**Your Ref: 2025/1071
Our Ref: B/00229**

Alexandra Working Mens Club, 59 High Street, Royston, Barnsley - (BARN) Erection of 9 detached dwellings

Thank you for consulting Yorkshire Water regarding the above proposed development. We have the following comments:

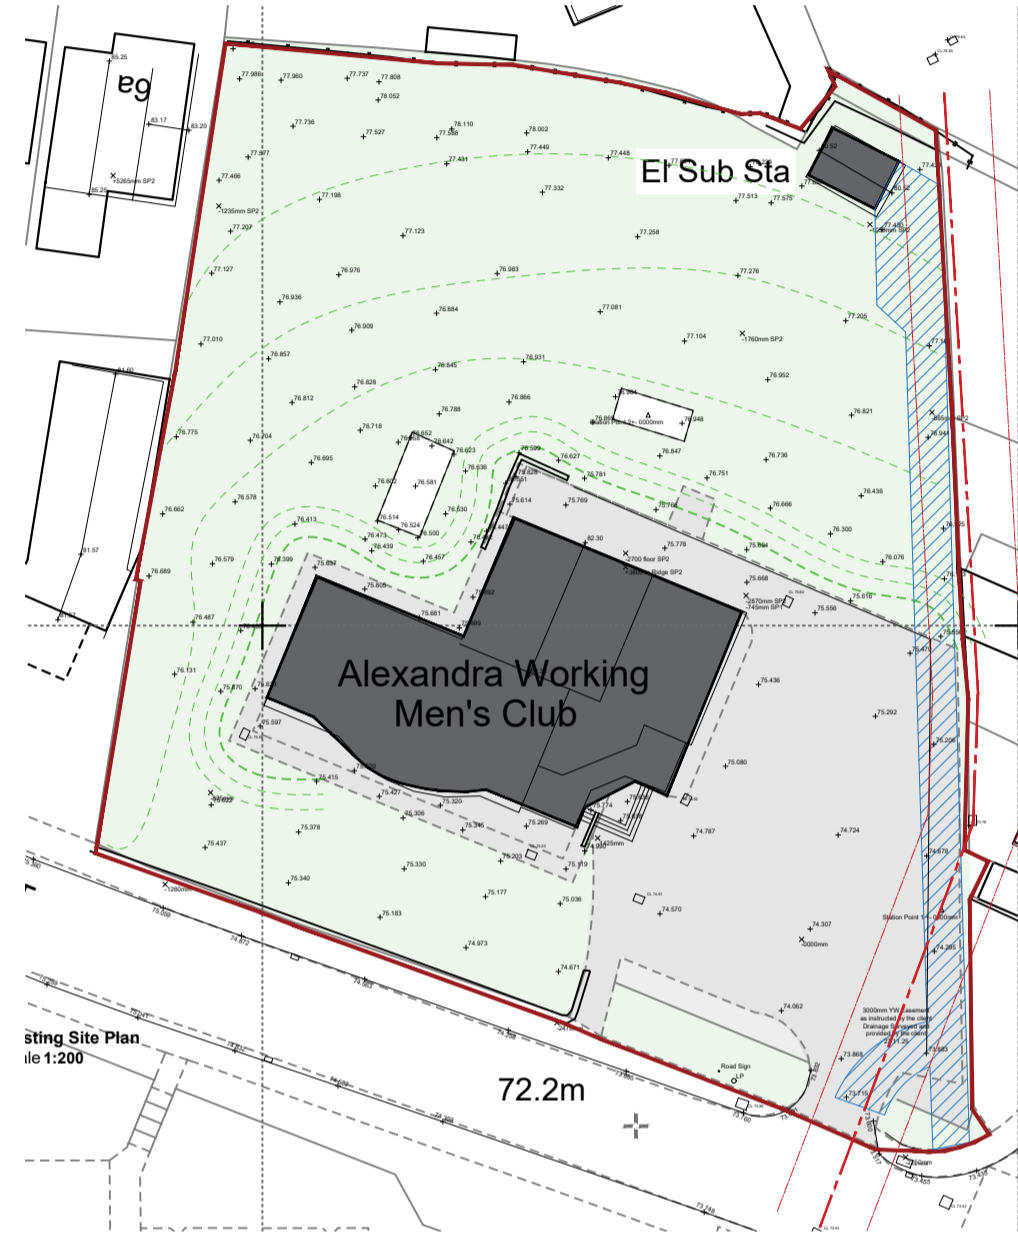
1.) The layout and landscaping details submitted on drawing 'HA-251101-Rev 11---Existing' (revision 13) dated that has been prepared by Hirst is not acceptable. The following point(s) should be addressed:

- a.) the submitted drawing appears to show new tree planting within 5 metres of the public sewer network.
- b.) the submitted drawing should show the site-surveyed position of the public sewer crossing the site
- c.) the submitted drawing should show the required building tree planting stand-off from public sewer -- or an agreed alternative scheme
